Road safety audit response report

Report title:	RSA Stage 1 – Proposed Access – Plot B Interchange 26
Date:	29/11/2024
Document reference and revision:	MAL/I26PBRSA1Rev1
Prepared by:	Meraki Alliance
On behalf of:	Kirklees Council

Project:	Proposed Access – Plot B Interchange 26
Report title:	Stage 1 – Road Safety Audit Response Report
Prepared by:	
Name:	Gavin Shepherd
Position:	Associate Director
Signed:	
Organisation:	Andrew Moseley Associates
Date:	29/11/2024
Approved by:	
Name:	
Position:	
Signed:	
Organisation:	
Date:

The scheme submitted for Audit is the proposed access arrangements and improvements associated with a new industrial development off Interchange Way, Oakenshaw. This designers response report relates to Stage 1 of the RSA by Meraki Alliance (MAL/I26PBRSA1Rev1).

Drawing: GENERAL ARRANGEMENT

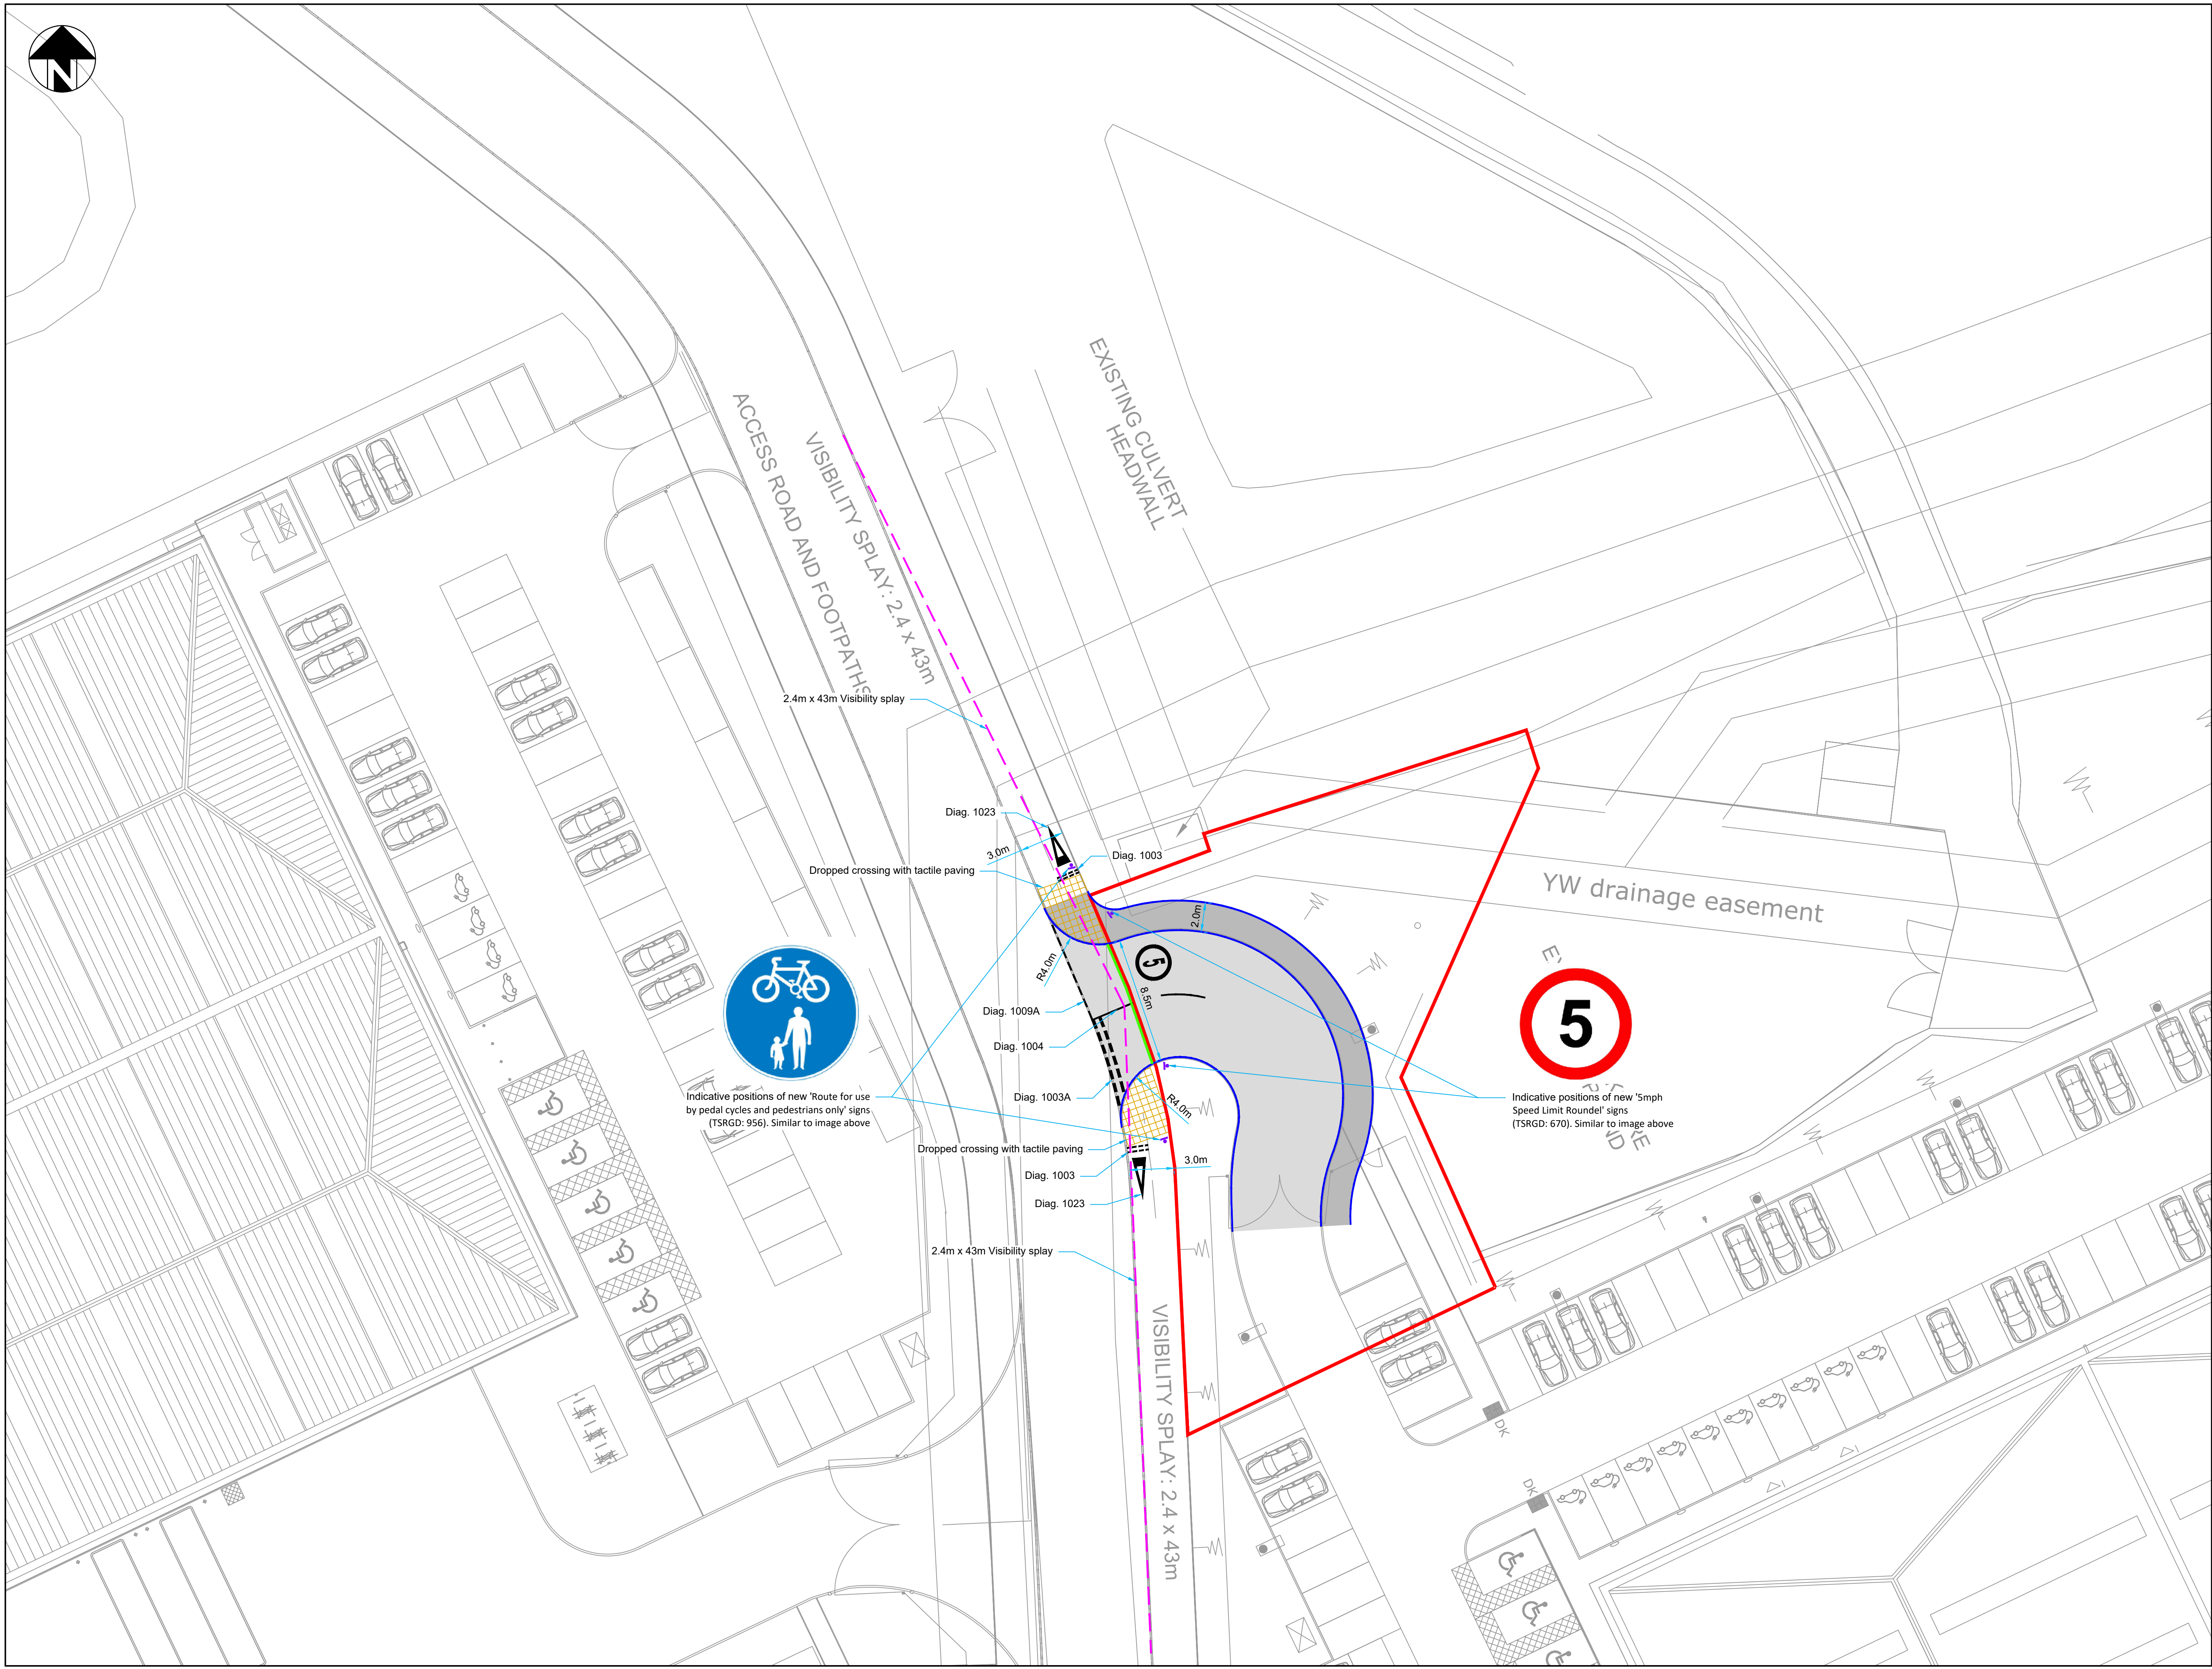
RSA PROBLEM	RSA RECOMMENDATION	DESIGN ORGANISATION RESPONSE	OVERSEEING ORGANISATION RESPONSE	AGREED RSA ACTION
During the site visit it was noted that the post and rail fence along the site frontage is incomplete. Also, the footway entering the site runs along an embankment. The drawings do not show if the post and rail fence will be completed and does not show any fencing along the footway to protect pedestrians from the embankment. A lack of suitable fencing will increase both the risk of pedestrians and cyclists	Provide appropriate fencing both along the site frontage and the access road.	Appropriate fencing will be added to the architects and the access drawings.

RSA PROBLEM	RSA RECOMMENDATION	DESIGN ORGANISATION RESPONSE	OVERSEEING ORGANISATION RESPONSE	AGREED RSA ACTION
falling down unprotected embankments
